From: Easements&Development [<mailto:Easements&Development@transgrid.com.au>]
Sent: Thursday, 16 August 2018 2:55 PM
To: DPE CSE Information Planning Mailbox <information@planning.nsw.gov.au>
Subject: 2018-363 Planning & Environment - Notification of Modification (SSD 7317 MOD 12)
Australian Technology Park

RE: 2018-363 - Planning & Environment - Notification of Modification (SSD 7317 MOD 12)
Australian Technology Park

Please be advised after reviewing the proposed Notification of Modification (SSD 7317 MOD 12)
Australian Technology Park

Threshold ID Totem

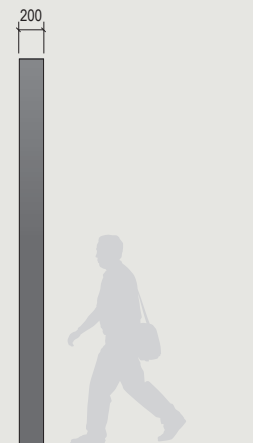
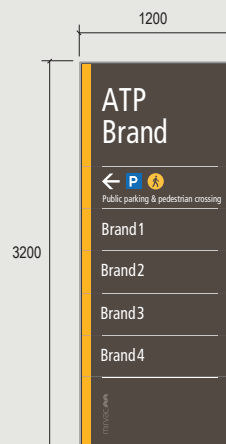
1. TransGrid **must** be able to maintain access to their portal in Australia Technology Park. Over the years these has been increasing vegetation growth narrowing access.
2. The proposed totem signage S1.B (screenshots below) is located in the access easement acquired for maintenance of the portal. It looks like it may impede access/egress and use of that area between the tree and the footpath for maintenance vehicle parking.
3. **TransGrid requests that the maintenance access requirements and easement be considered as part of the masterplan.**
4. The current access point to the tunnel portal being off Henderson St (near Davy Rd)
5. Vehicular travel to the tunnel portal is currently still possible within the grounds.
